RE: 127 Pennell Avenue – 347-B-004 – R-3 Zone

I am in receipt of your application to construct a single family dwelling 28' x 40' with an attached two car garage. Your permit is not meeting the current dimensional requirements for the R-3 zone. Your permit has been denied.

REAR ELEVATION
SCALE: 1/4" = 1'-0"

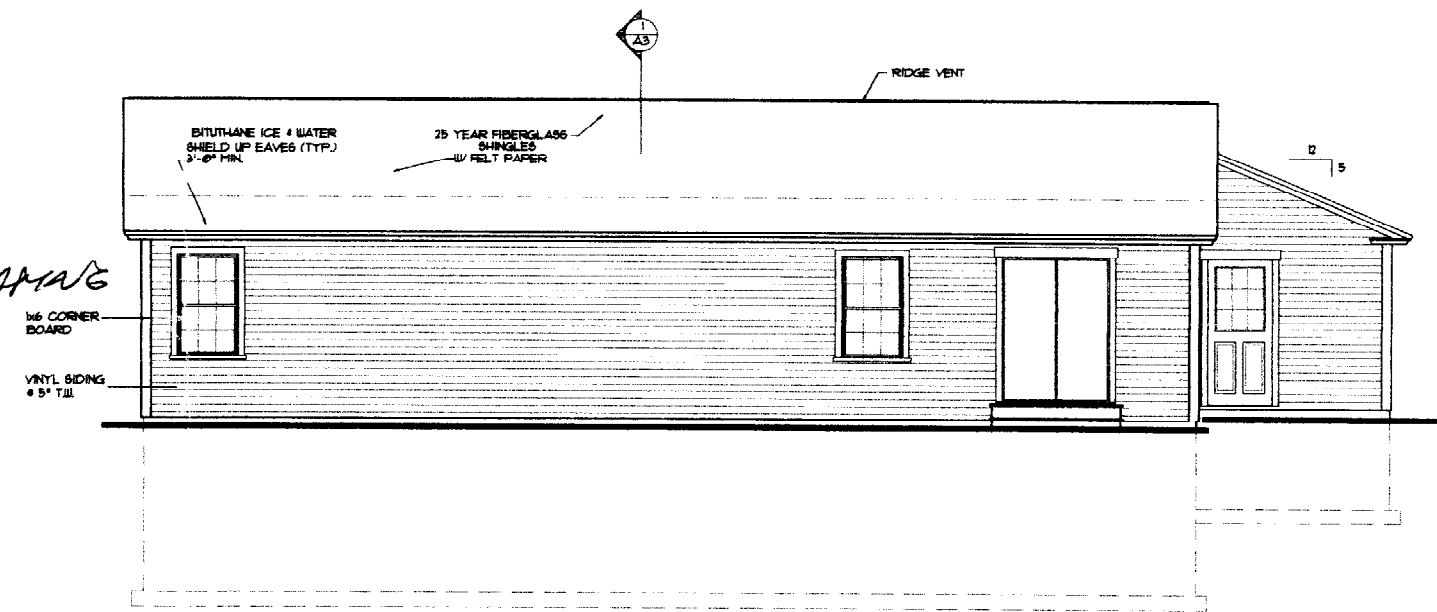
First, in the R-3 residential zone, there is a requirement of no more than 25 percent lot coverage for structures. This lot is 7,500 square feet in size. 25 percent of 7,500 is 1,875 square feet. My calculations show that the actual lot coverage of building area is 1,946 square feet which is over the maximum allowance. This actual lot coverage also does not count in several rear steps from the rear slider. These steps are shown only on your building plans and not on your site plan.

This application is also being denied because of these same steps off the rear slider. Your submitted plot plan shows exactly 25 feet from the rear of the building to the rear property line. In order to have a rear slider with an exit, it will be necessary to install rear steps. This is not shown and would be impossible under zoning. The structure would be closer than 25 feet to the rear property line. This problem should be resolved now and not later after construction. This violation of the setback would be a variance appeal to the Zoning Board of Appeals. Again, this problem should be resolved now and not be a burden upon a future property owner.
